Application No: 17/00569/DISC

Proposal: Discharge of Conditions 26 (lighting scheme), 53 (existing and proposed site levels), 75 (scheme for the protection of retained trees), 78 (supervision for the arboricultural protection measures), 81 (ecology mitigation), 82 (bat, bird, owl and invertebrate boxes location) and 83 (ecological construction method statement) of 10/01780/HYBRID

Location: Bicester Eco Town Exemplar Site, Banbury Road, Bicester.

Objection to discharge Condition 26 of 10/01780/HYBRID

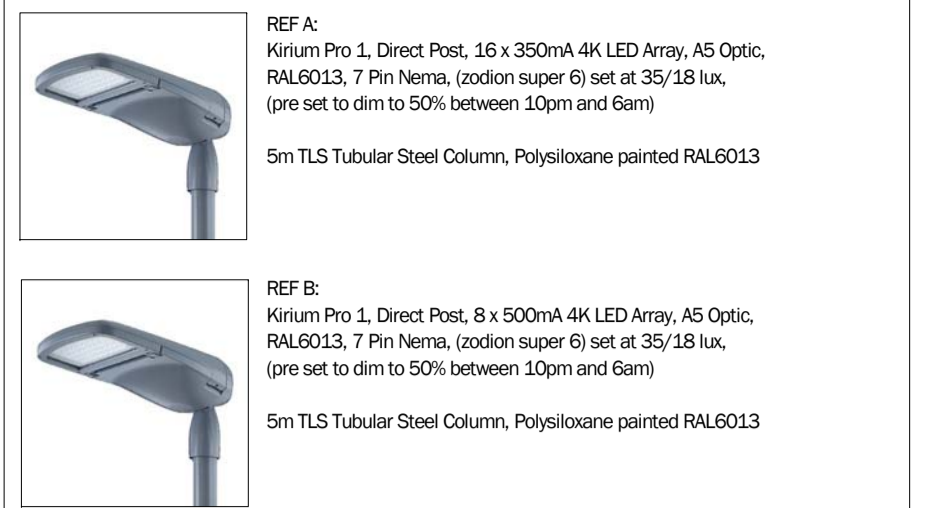
Drawing 13741-1-A (Elmsbrook Phase 3 / 4)

The above drawing(s) have been reviewed. However, the information provided is insufficient to recommend discharge of condition 26 of 10/01780/HYBRID.

As far as OCC (Highway Authority) is concerned, the applicant has not submitted an adoption plan to inform of which parts of the development are intended as future highway. Adopted areas of a development usually require specific lighting design and without this information (adoptable areas), I cannot recommend the discharge of this condition.
